**RE: East Fork Jimmy Camp Creek at Creekside at Lorson Ranch, El Paso County,
Colorado CDR 192 (Kiowa Project No. 18020)**

I have prepared responses to PCD-Engineering's third set of review comments summarized in the County's memorandum dated June 3, 2020. Kiowa's responses are as follows:

LORSON RANCH
CREEKSIDE DEVELOPMENT
EAST FORK JIMMY CAMP CREEK
CHANNEL PLAN AND PROFILE STA 35+00 TO STA 45+00
EL PASO COUNTY, COLORADO

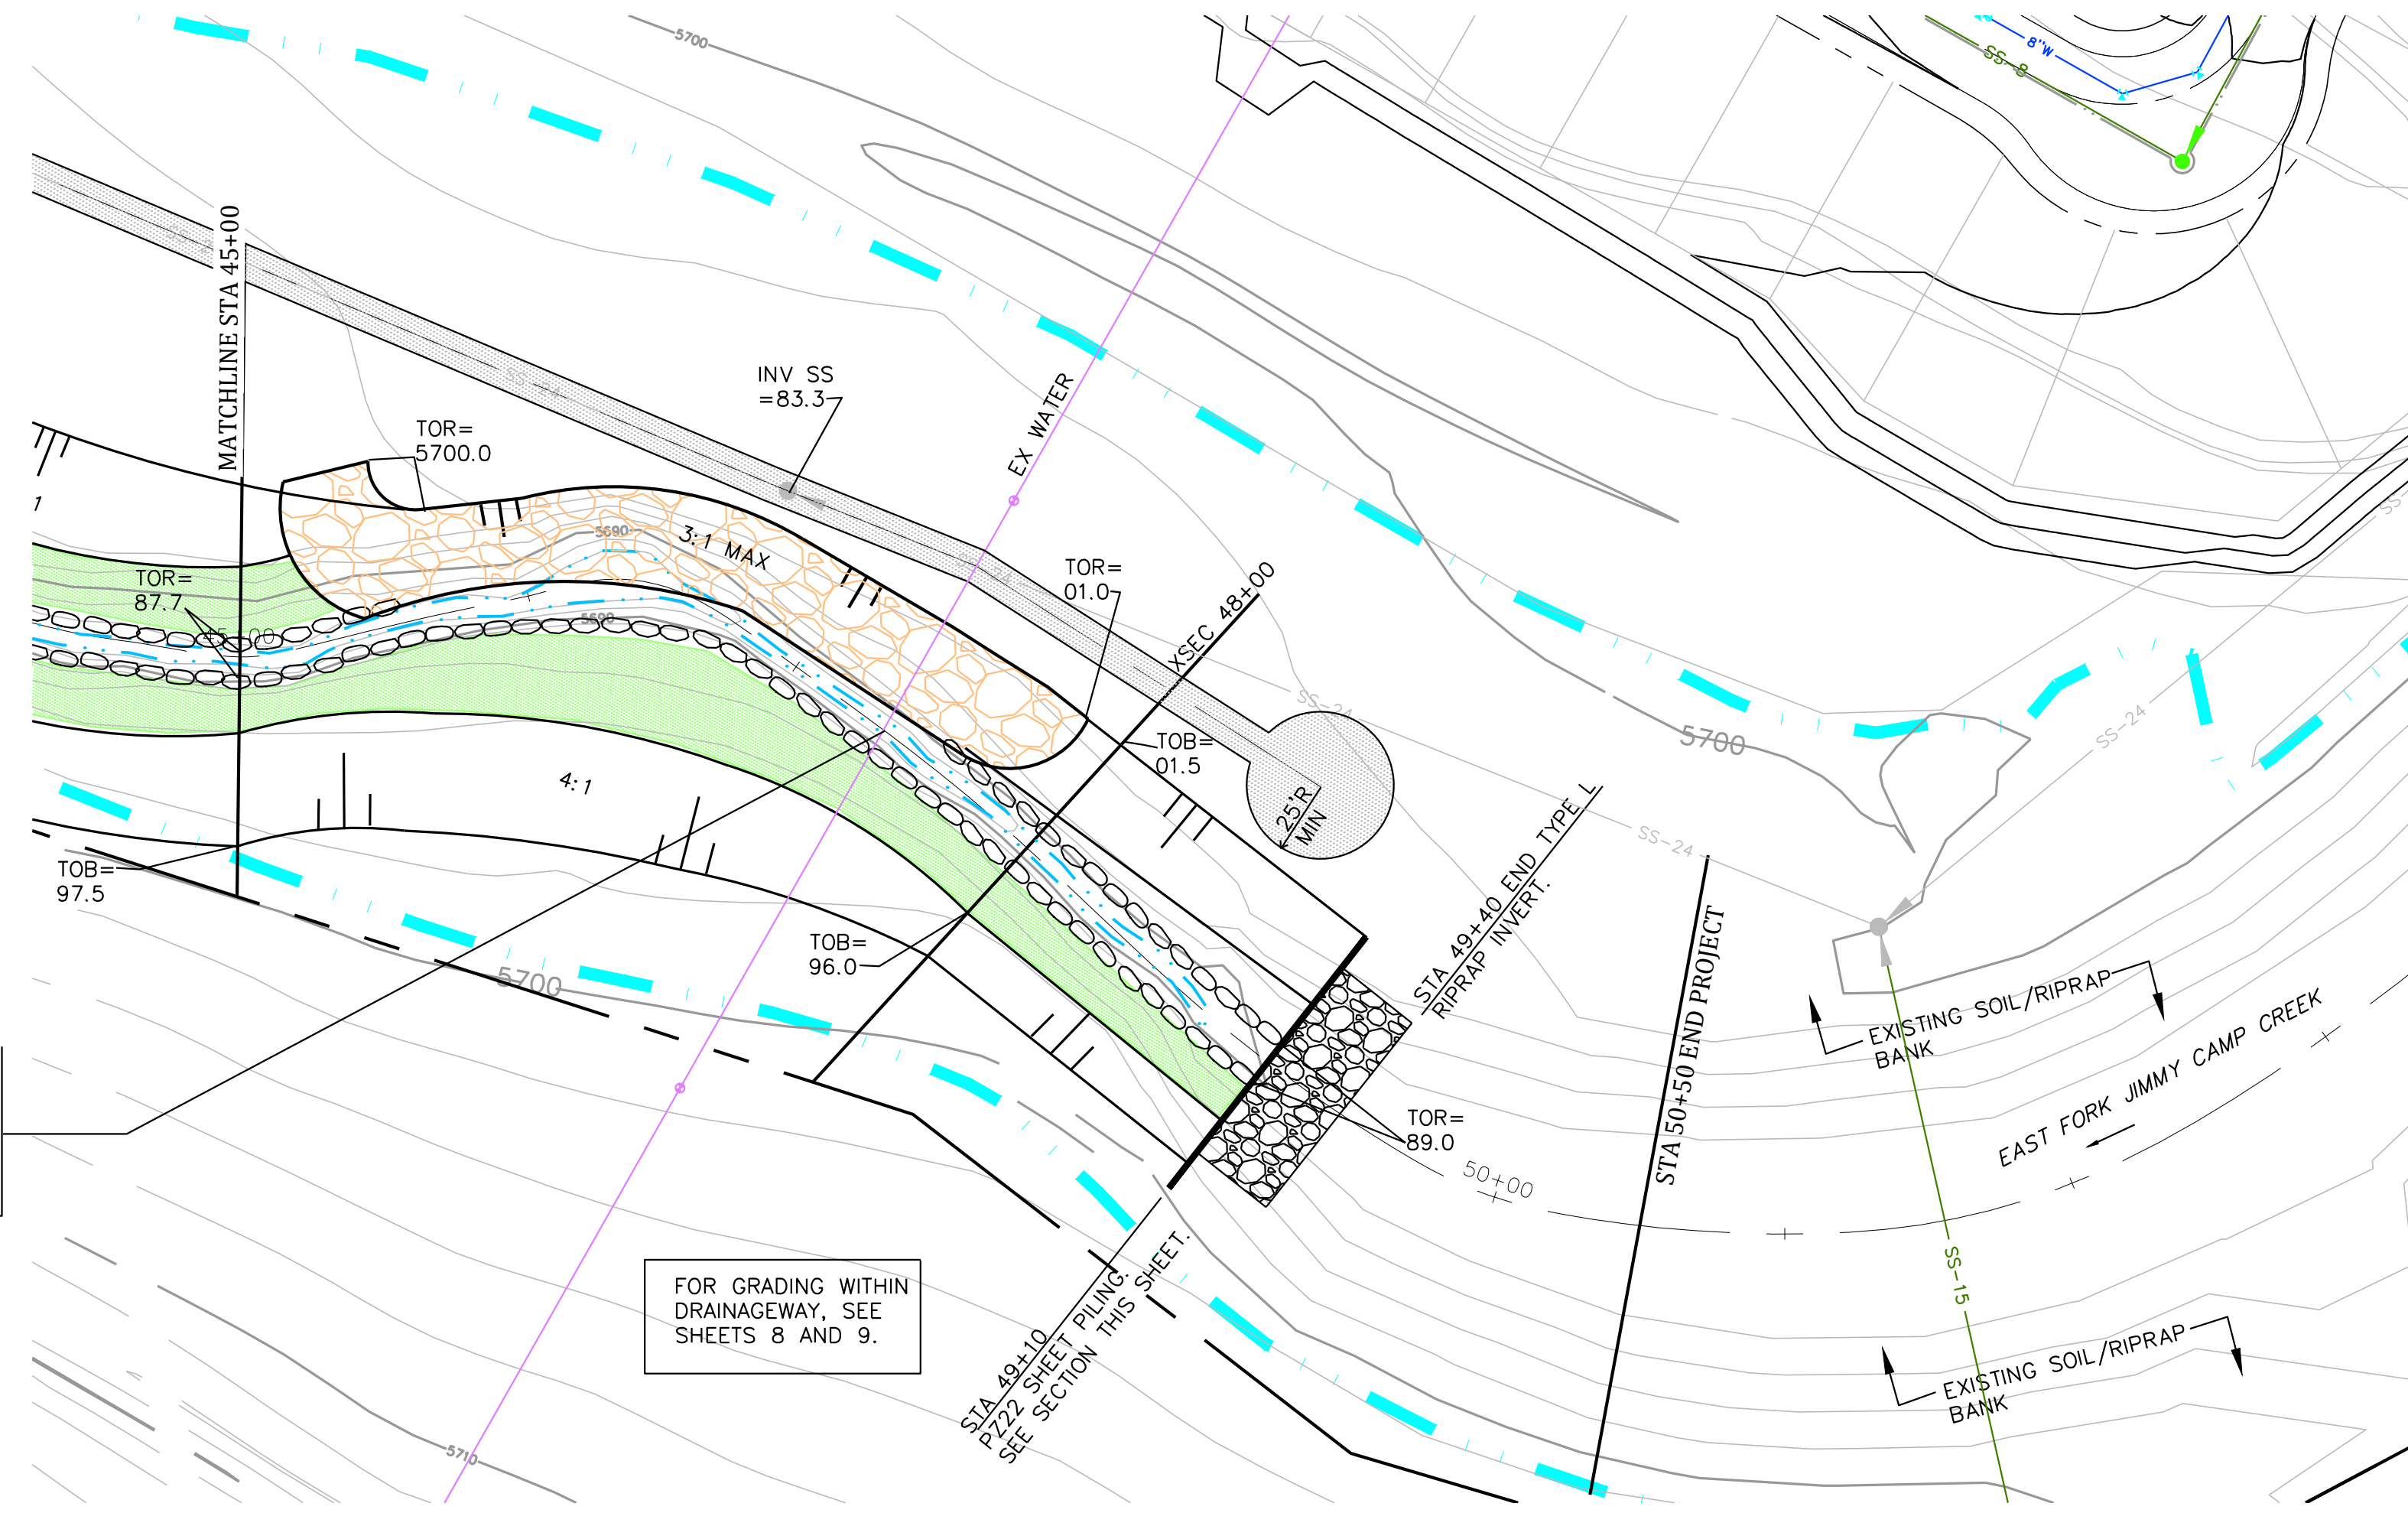
6. Profile of 18-inch outlet pipe and spillway from Creekside Filing 1 FSD CR2 has been added to the plan sheets, specifically on sheet 4 of the construction drawings.
